Resource and Energy Assessments
Planning and Assessment Division
Department of Planning, Industry and Environment

**EPA Advice on Environmental Impact Statement – Further Information Required –
Burrendong Wind Farm (SSD-8950984)**

Thank you for the request for advice from Public Authority Consultation (PAE- 64738216), requesting the review by the NSW Environment Protection Authority (EPA) of the Environmental Impact Statement (EIS) for the proposed Burrendong Wind Farm (Application SSD-8950984) located approximately 30km west of Mudgee in NSW, predominantly in the Yarrabin area, within the Dubbo Regional and Mid-Western Regional Local Government Areas (LGA).

Figure 2: Estimated ground vibration levels for $K_g = 1140$ and $B = 1.6$

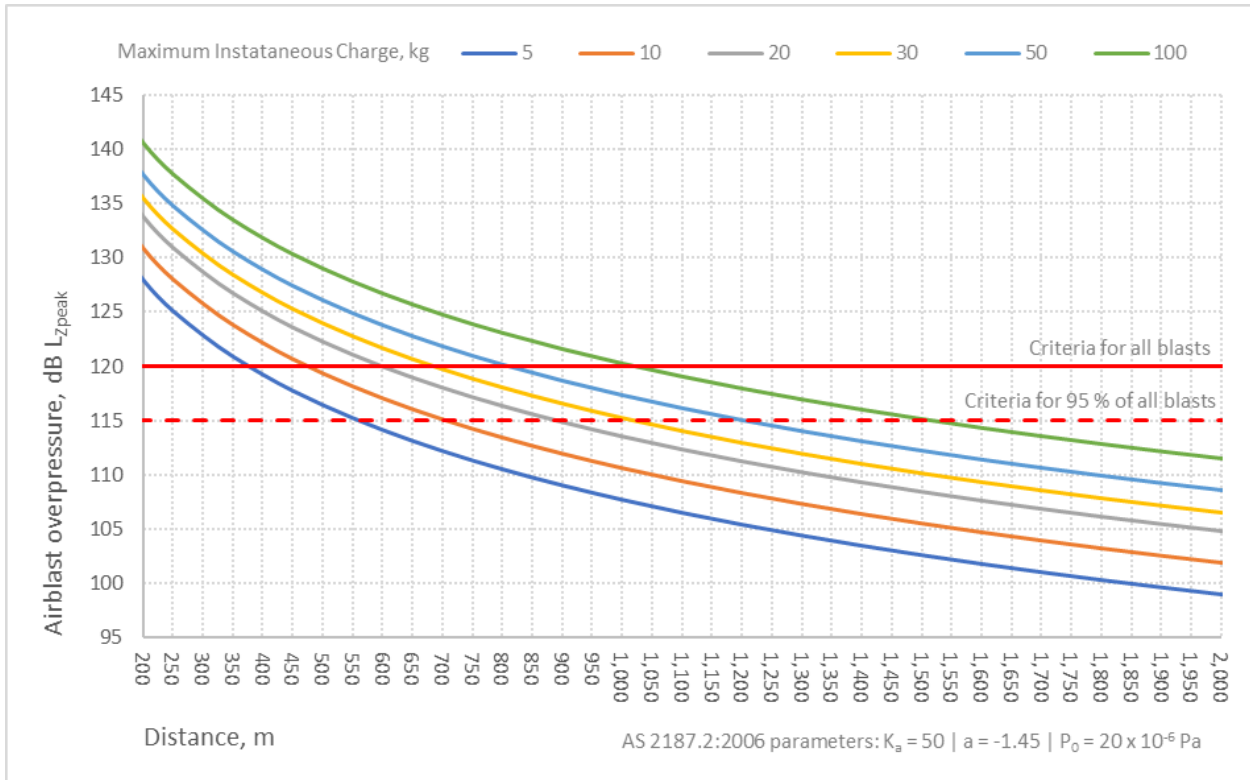
In Section 9.4 of the NVIA, no project-specific prediction of blasting and construction vibration impacts at sensitive receivers or discussion of reasonable and feasible mitigation has been provided.

The planning department may wish to request that any impacts associated with blasting (airblast overpressure and ground borne vibration) and construction vibration are identified, and reasonable and feasible mitigation is discussed where appropriate to satisfy the SEARs.

Figure 5: Highest predicted noise level contours

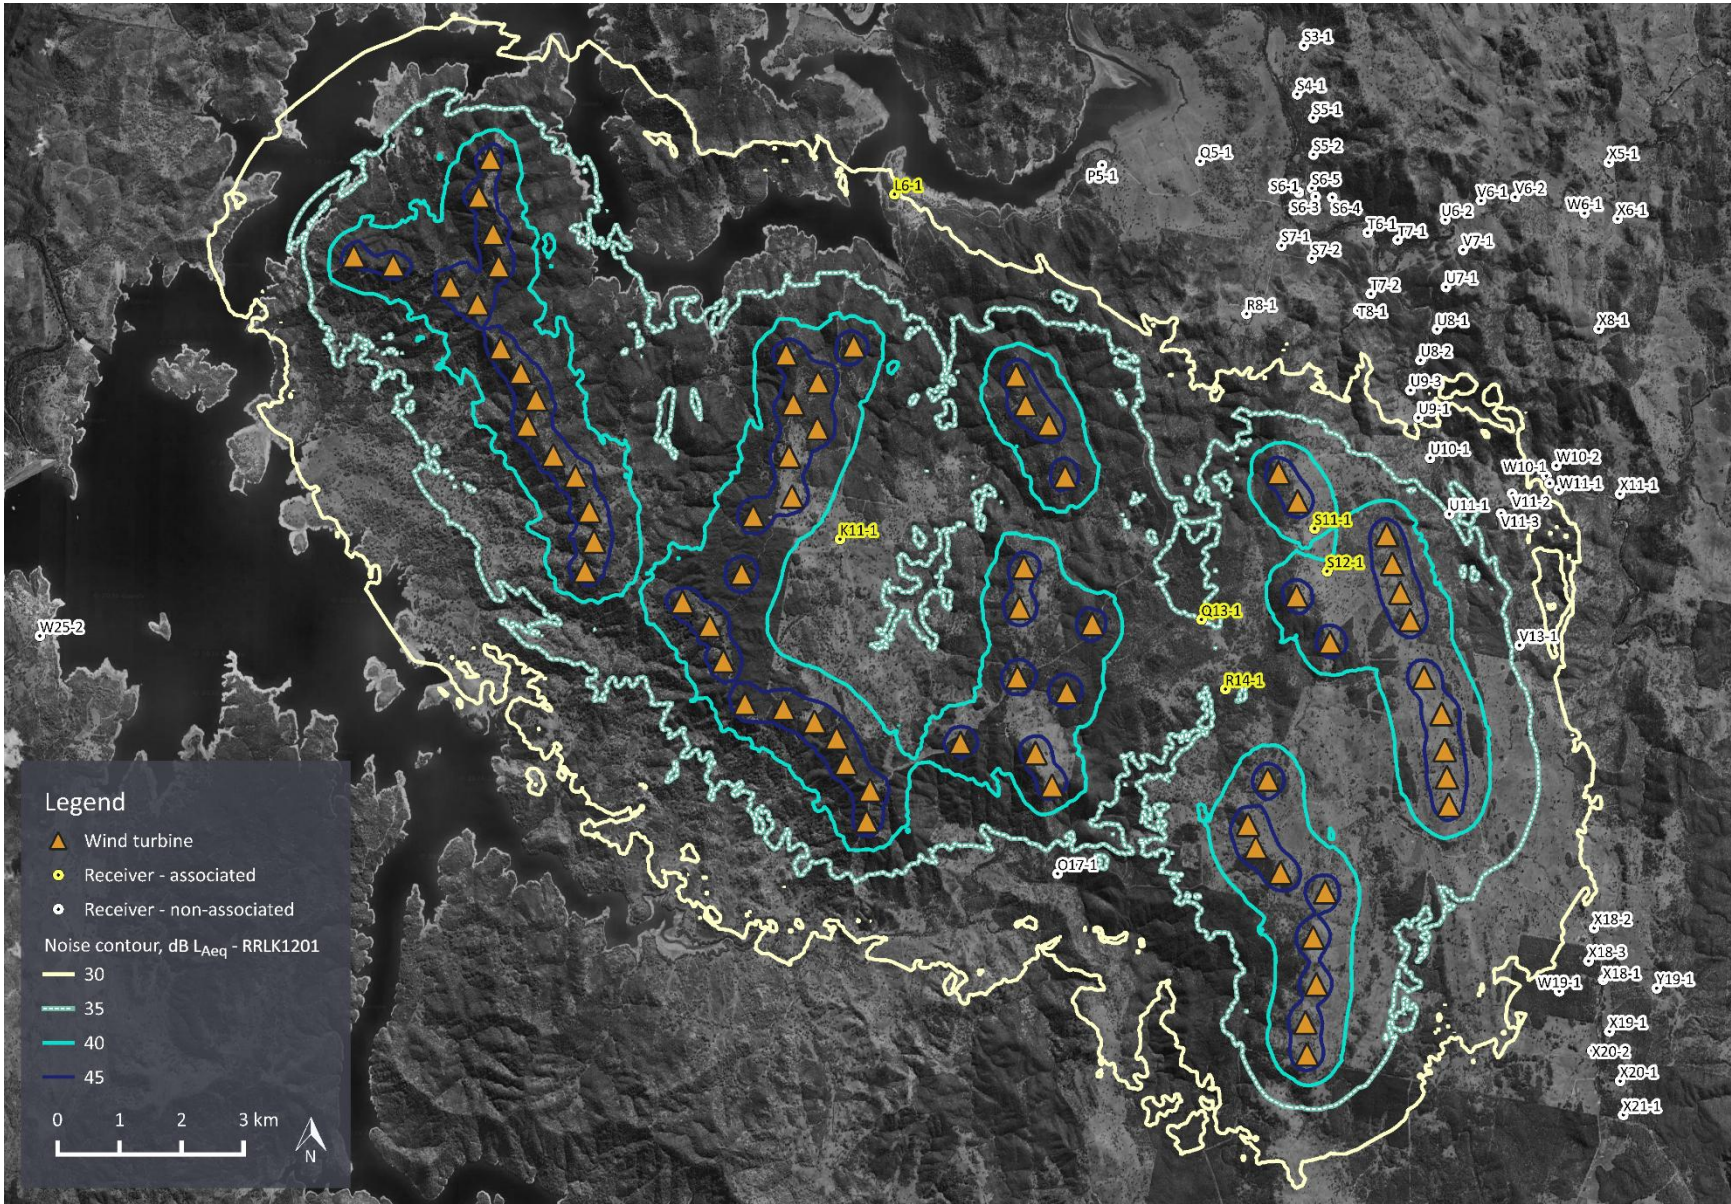
The EPA requests that operational noise limits for the windfarm are updated to reflect a 24-hour period rather than day/night, in line with the *Wind Energy: Noise Assessment Bulletin*.

The EPA requests that a sensitivity analysis of the modelled receiver height's impact on the predicted noise levels is provided to justify the use of 1.5 metre receiver heights.
